Axis J9 Phase 3

Technical Note - Response to OCC Highways Consultation Response 22/2/22
Application No. 21/03177/F

JOB TITLE		ALBION LAND	
DRAWING TITLE		HOWES LANE CROSSING	
SCALE	DRAWN BY	DATE	DRAWING No
1:125@A1	RM	08/03/22	14042-60-CY
REVISION			M

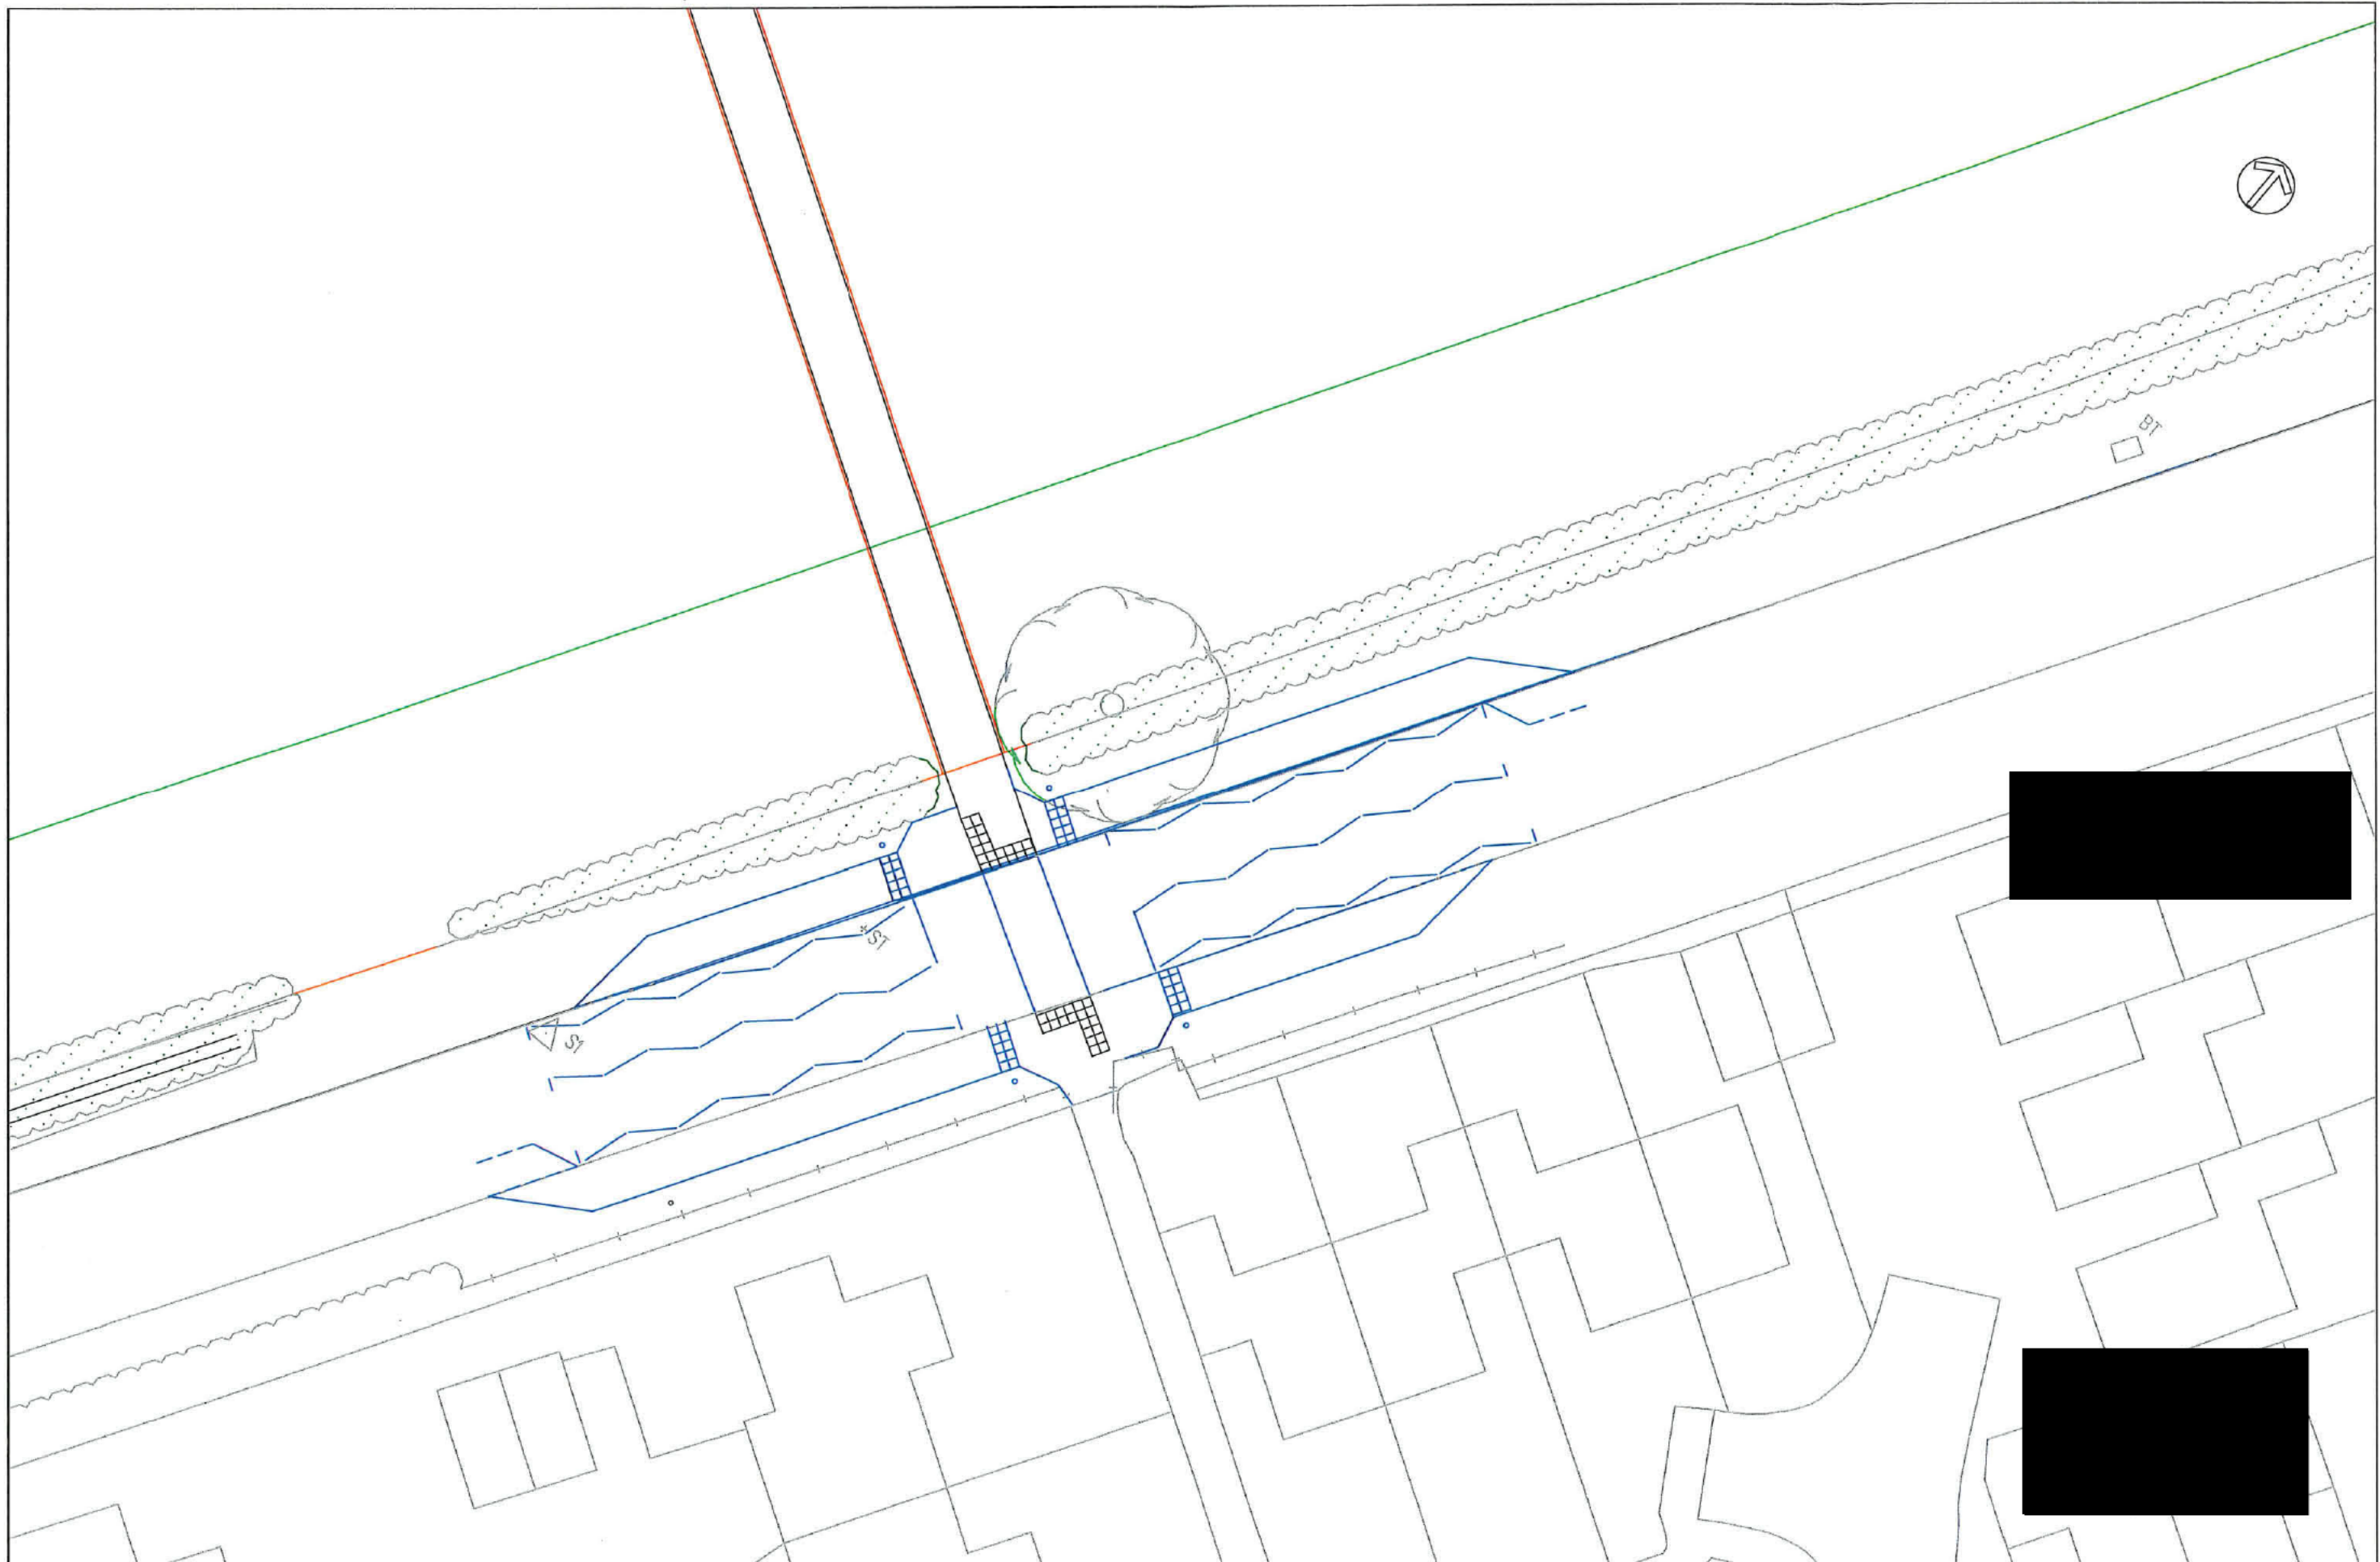
4. The link between the SLR and Howes Lane had been included as a footway/cycleway. There was therefore no intention of cyclists wheeling their bikes along its length. The barrier chicane feature at the crossing approach had been explicitly recommended by the independent road safety auditor to protect pedestrians from potential collisions with cyclists at the crossing point; and to protect cyclists from potential collisions with vehicular traffic at the crossing point if cyclists approached the crossing at speed.

On behalf of the applicant, DTA accepted the identified problem in the RSA and in the Designers' Response referred to the design solution being agreed as part of the detailed design and hence conditioned. The applicant's design team see merit in safety auditor's recommended chicane feature. The agreement as to the most appropriate way of ensuring safe cyclist speeds to ensure a safe environment for all modes, will be progressed post planning by the applicant's detailed designer in discussion with the OCC S38 engineer.

Notwithstanding the detailed discussion to follow on the link itself has been widened from 2.5m to 3m. The amendment is shown on **DTA Drawing 14042-60-GA-Rev N**.
